**PLAN REVIEW SHEET**

**Petition #: RZP 2021-169**

**Address: 1818 Mt. Holly-Huntersville Rd.**

**Request: NS**

JOB NO.	99999
SHEET NO.	RZ-100

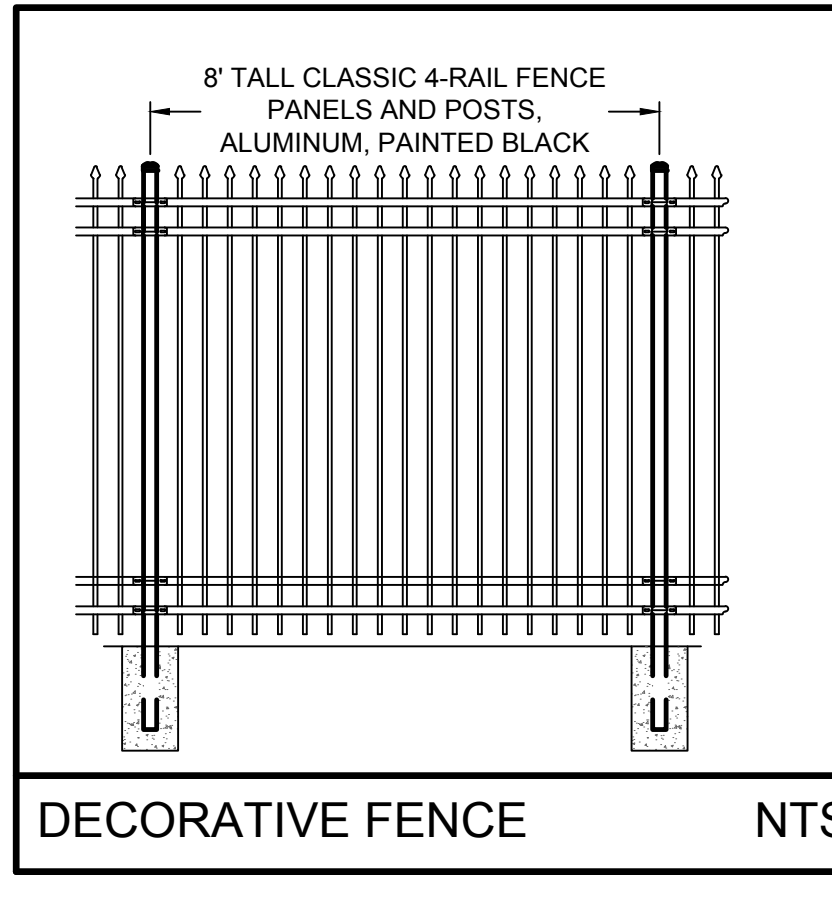
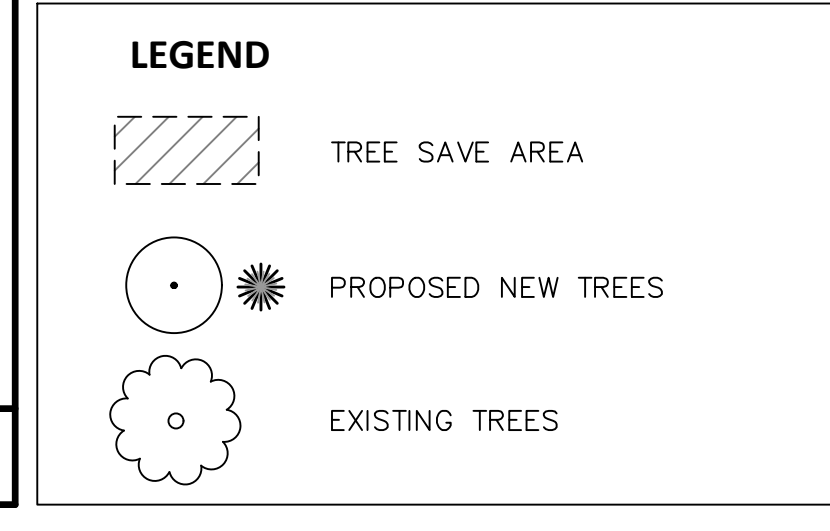
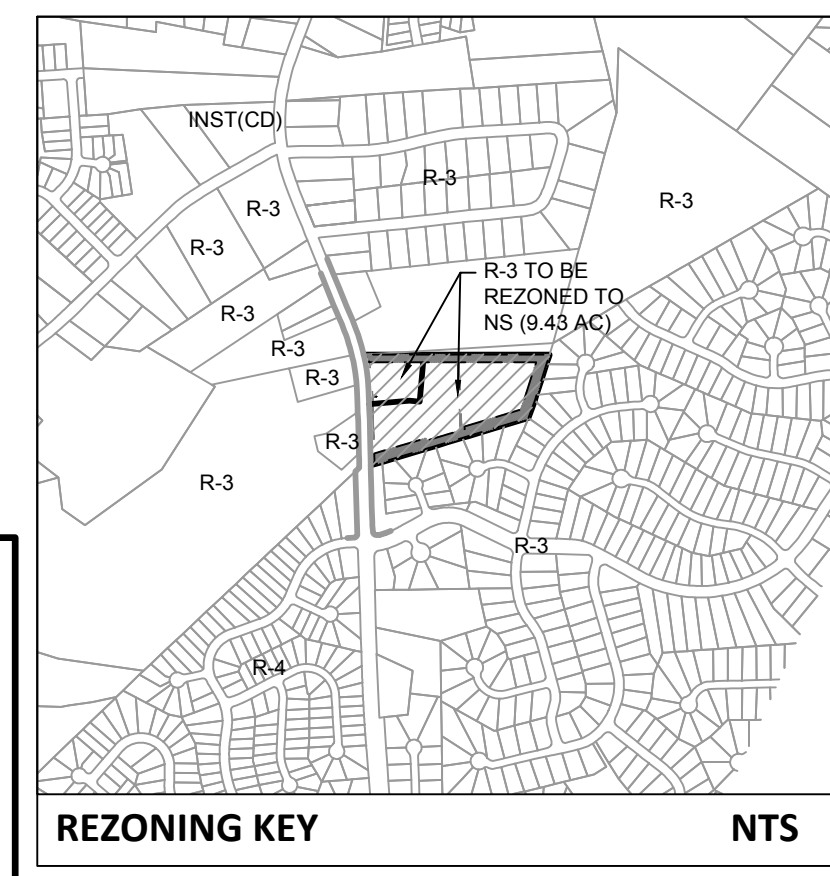
The site is located along CATS local bus route #18 on Mt. Holly-Huntersville Rd. CATS requests the construction of an ADA compliant waiting pad per Land Development Standard 60.01B on Mt Holly-Huntersville Rd. The final location of the pad will be coordinated with the developer through the permitting process.
